# BUSHFIRE HAZARD ASSESSMENT REPORT

| REPORT PREPARED IN<br>RELATION TO:     | RESIDENTIAL SUBDIVISION                                         |
| PROPERTY DESCRIPTION:                  | LOT 112 DP 1073791<br>off LYONS ROAD,<br>TOORMINA, via SAWTELL. |
| REPORT COMMISSIONED BY:<br>(my Client) | Utila Pty Ltd,<br>c/- Mr Adrian Borsato                         |

ROAD PROFILE 7

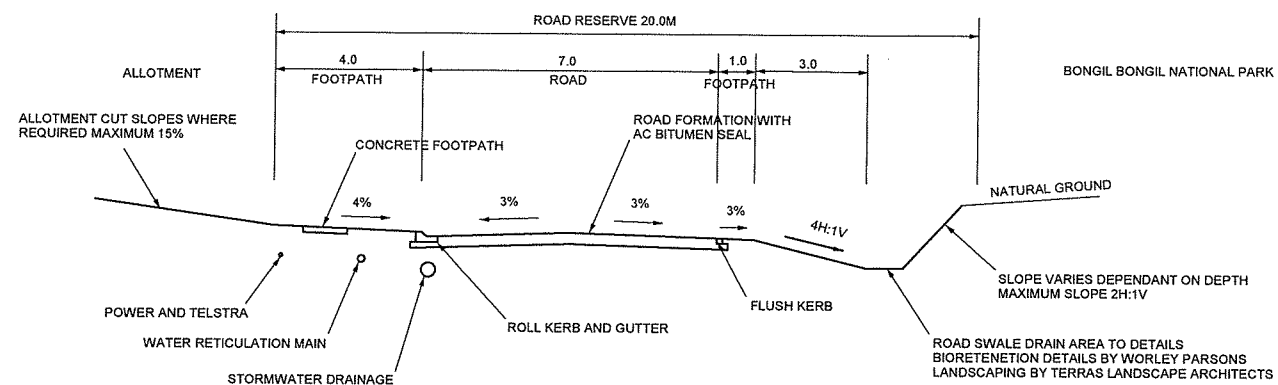
- Road profile number 7 indicates that the perimeter road has a proposed carriageway width of 7 metres. The requirement is 8 metres similar to proposed Roads 5 & 6;

- o All of the road widths need to be rechecked to ensure compliance with the relevant *Acceptable Solutions* of **PBP-2006**. As stated in the previous versions of my Report, “All

of the *Acceptable Solutions* above are able to be incorporated into the design of the public road network for the proposed subdivision.”
